STATE OF NORTH CAROLINA  
DEPARTMENT OF TRANSPORTATION

December 15, 2020

Subject: Request for Modification to the Phased Section 404 Individual Permit and Section 401 Individual Water Quality Certification, Neuse River Riparian Buffer Authorization, Non-404 Jurisdictional Wetlands and Waters Permit for the Construction of the Triangle Expressway Southeast Extension from NC-55 Bypass in Apex to I-40, Wake and Johnston Counties. TIP Nos. R-2721, R-2828, and R-2829. Debit \$570 from WBS 37673.1.TA1.

PERMIT DRAWING
SHEET 20 OF 69

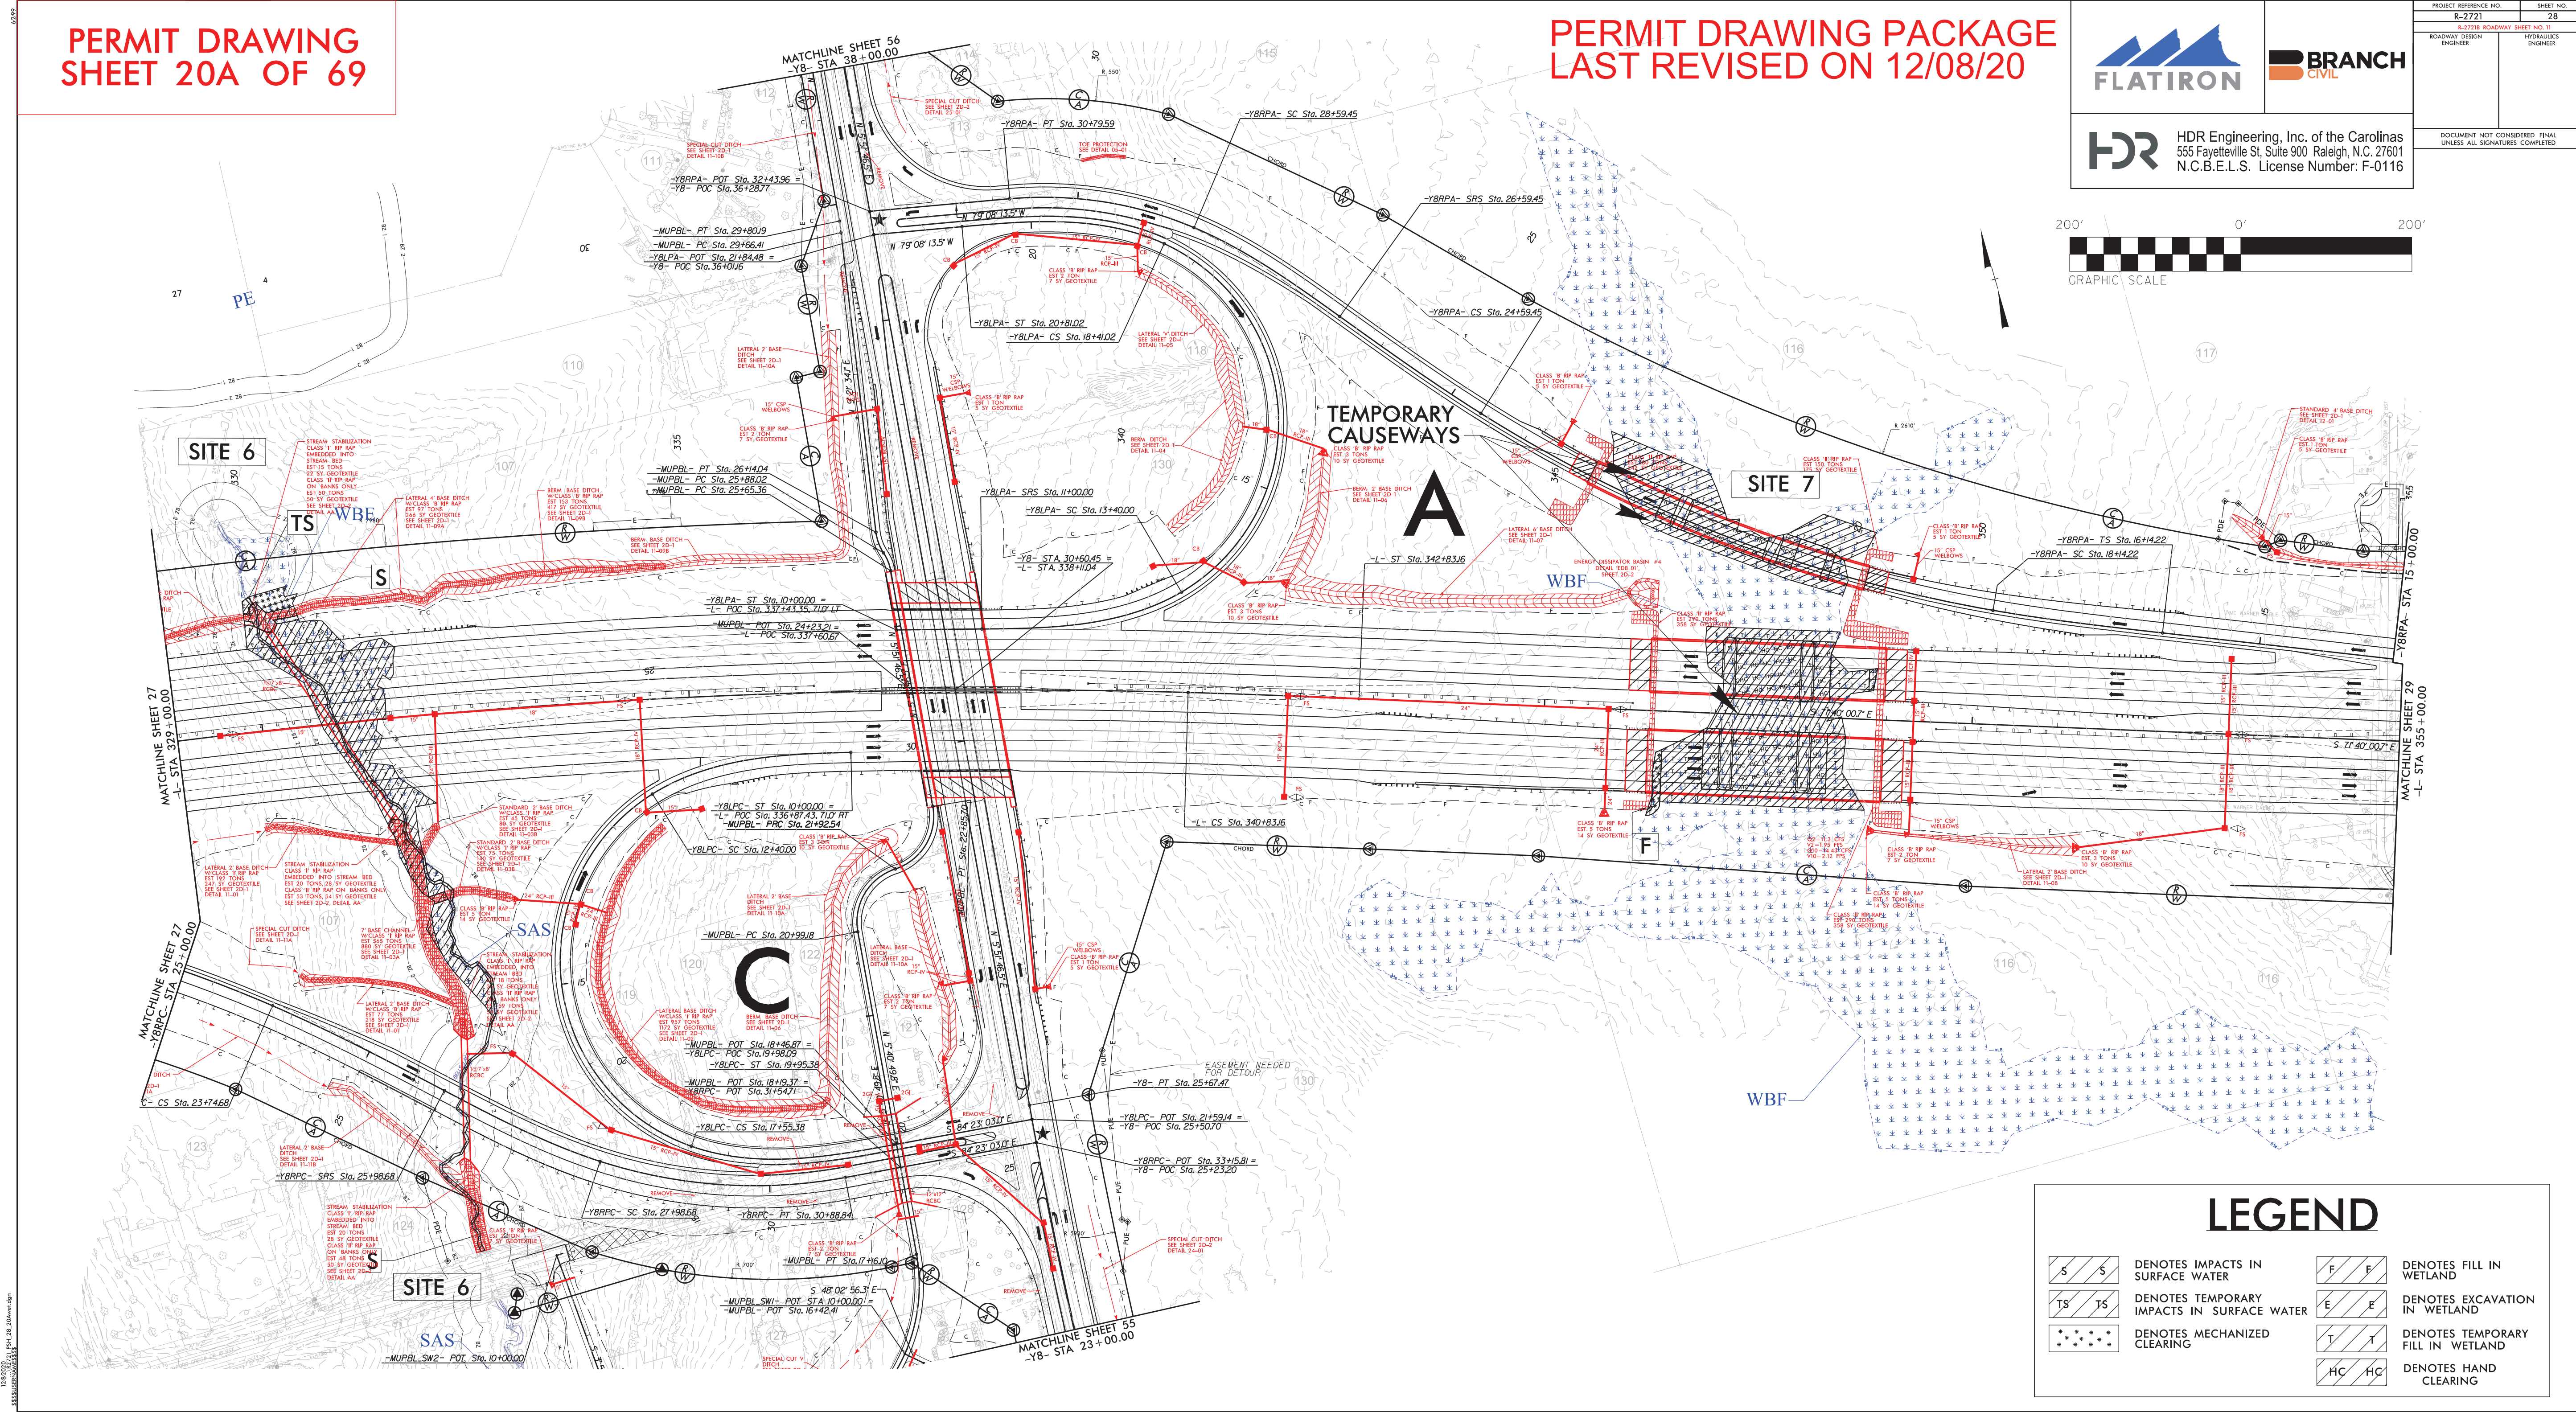
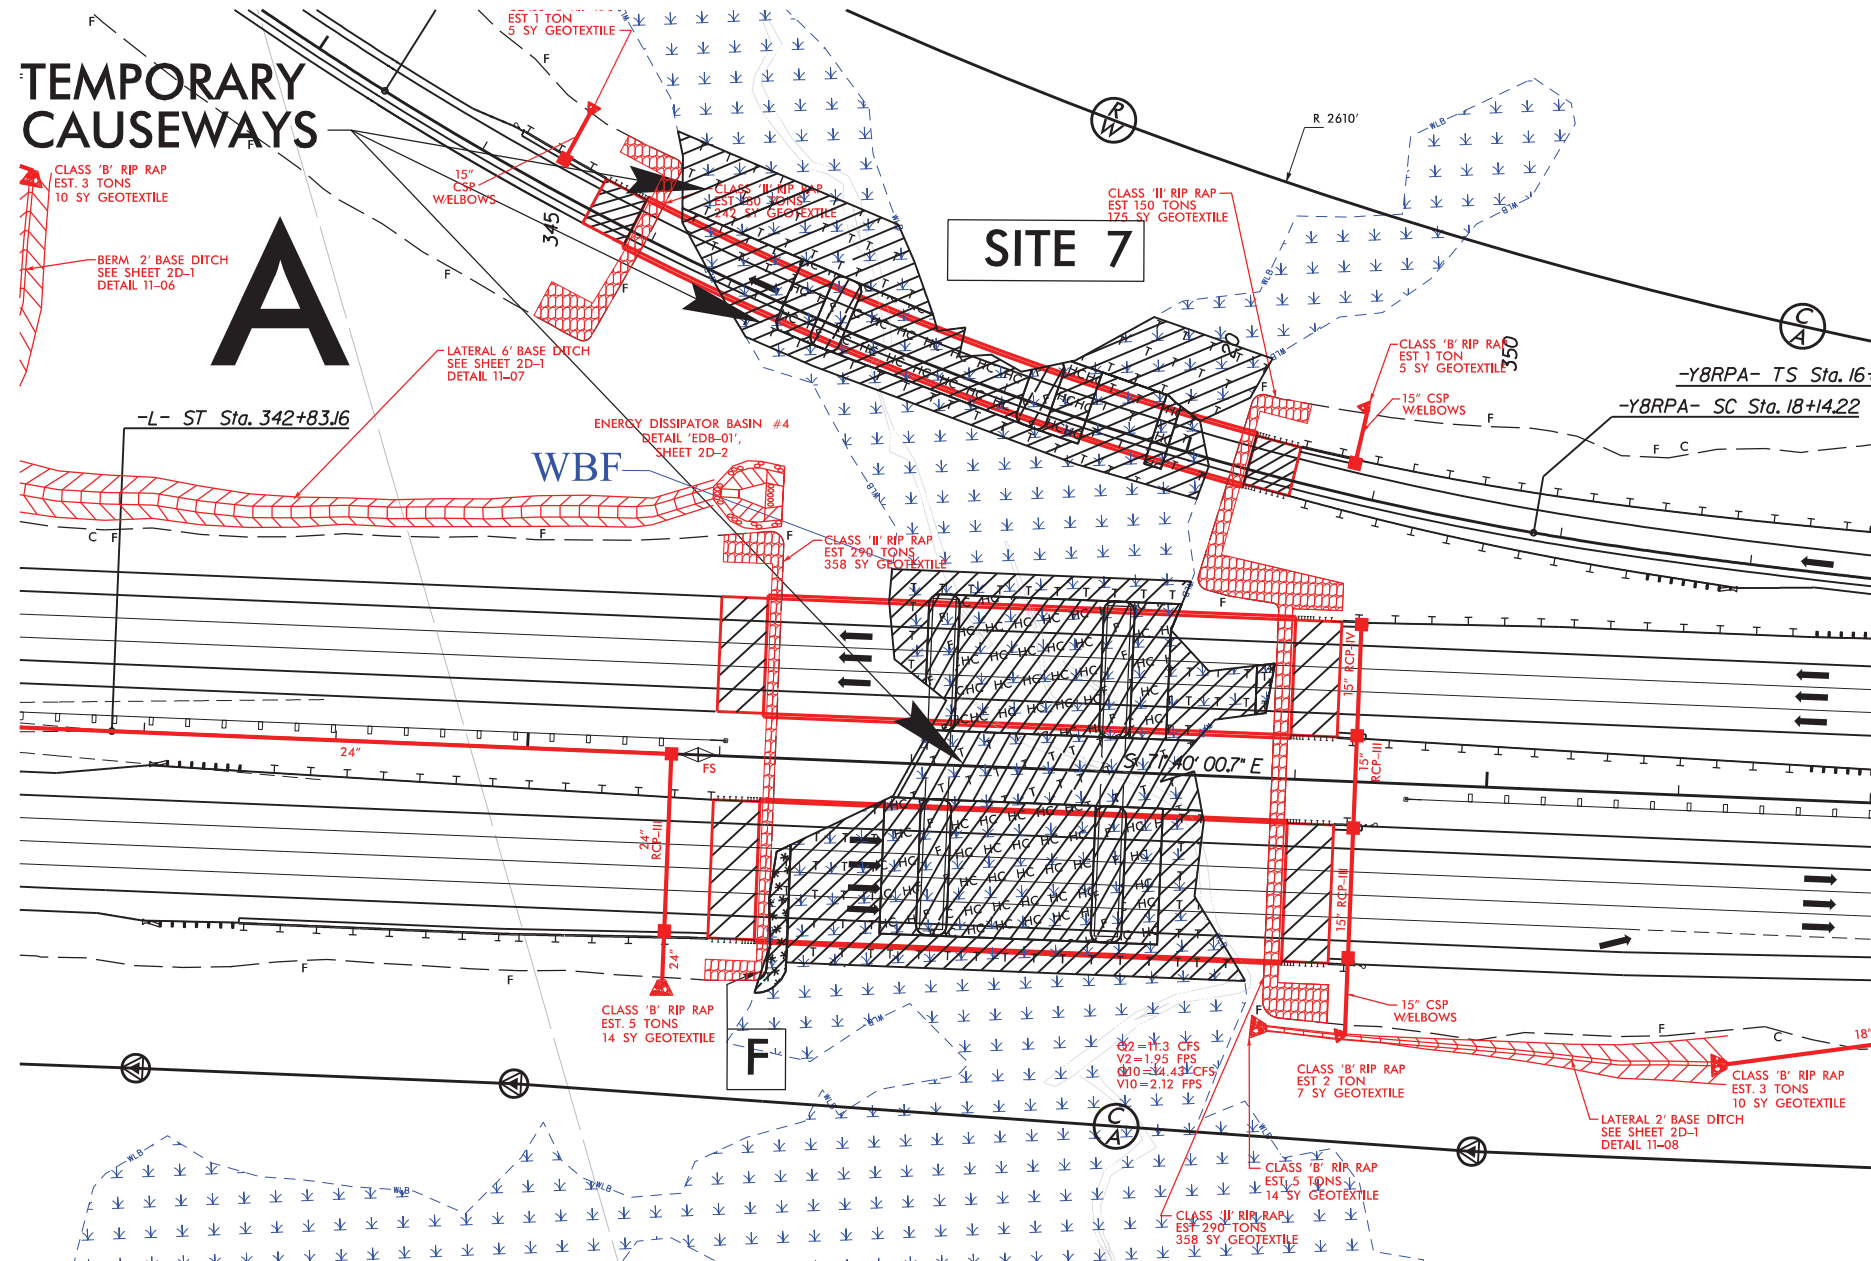
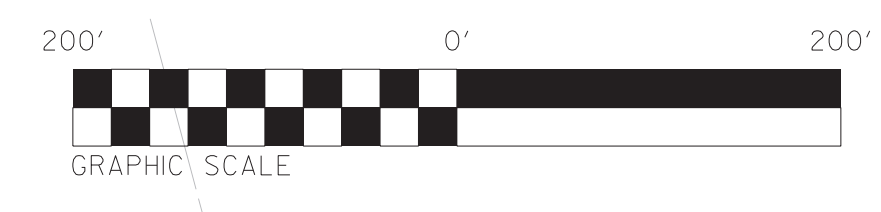
During the final design of the bridges at Permit Site 7 on the R-2721B Section, the Design-Build Team changed the span arrangement of the mainline bridge from a five span bridge to a three span bridge as well as the ramp bridge from a five span bridge to a three span bridge. By incorporating these changes there is a decrease in permanent fill impact by 0.08 acre related to the bridge bents.

Also, during this process the contractor realized that they would need to have additional temporary impacts in order to build the ramp bridge. The site does not provide enough room for them to move and place their cranes at the locations required within the currently permitted footprint. To the north side of the ramp bridge they will need an additional 0.10 acre of temporary impact beyond what was previously permitted as hand clearing. The area is now shown as temporary impact due to the need for either a causeway or crane mats. Where possible the contractor would utilize crane mats but this is likely not possible for the entire area shown as temporary impact. If a causeway or rock placement for leveling the crane mats is required, then the contractor will have geotextile fabric placed prior to rock being installed in order to maintain a barrier between the original ground and fill material. This will aid in removal of the rock.

Similar to the ramp bridge, the mainline bridge was evaluated for construction and the types of impacts have changed location. The site was previously permitted with a causeway with a number of fingers. The contractor has realized the fingers would not be necessary; however, temporary impacts would be needed at different locations to accommodate the cranes and causeway. Temporary impacts are now illustrated down the center of the alignment, to the outside of the bridge, and along the bridge abutments in order to have room for movement of the cranes. As stated above, the contractor will utilize crane mats where possible. Mechanized clearing was able to be reduced slightly. Please note that mechanized clearing is illustrated on the plans but this area would also be potentially impacted temporarily with the causeway or crane mats. It was shown as mechanized clearing due to the mitigation requirement for mechanized clearing as opposed to temporary impacts.

Due to the types of impacts changing location, there will be an increase in temporary impacts of 0.28 acre which is a change from 0.46 acre to 0.74 acre. There will be a decrease in the hand clearing impacts by 0.09 acre which is a change from 0.55 acre to 0.46 acre. There is a decrease in mechanized clearing of 0.01 acre which is a change from 0.03 acre to 0.02 acre. There is also a decrease in permanent impacts by 0.08 acre for the bridge bents which is a change from 0.20 acres to 0.12 acres of permanent fill. There is an increase in total impacts at Permit Site 7 by 0.10 acre due to temporary fill impacts replacing hand clearing, at the request of the USACE, but a decrease in overall project impacts. Please see the enclosed revised permit drawings and updated impact summary sheets which reflect the changes in impacts.
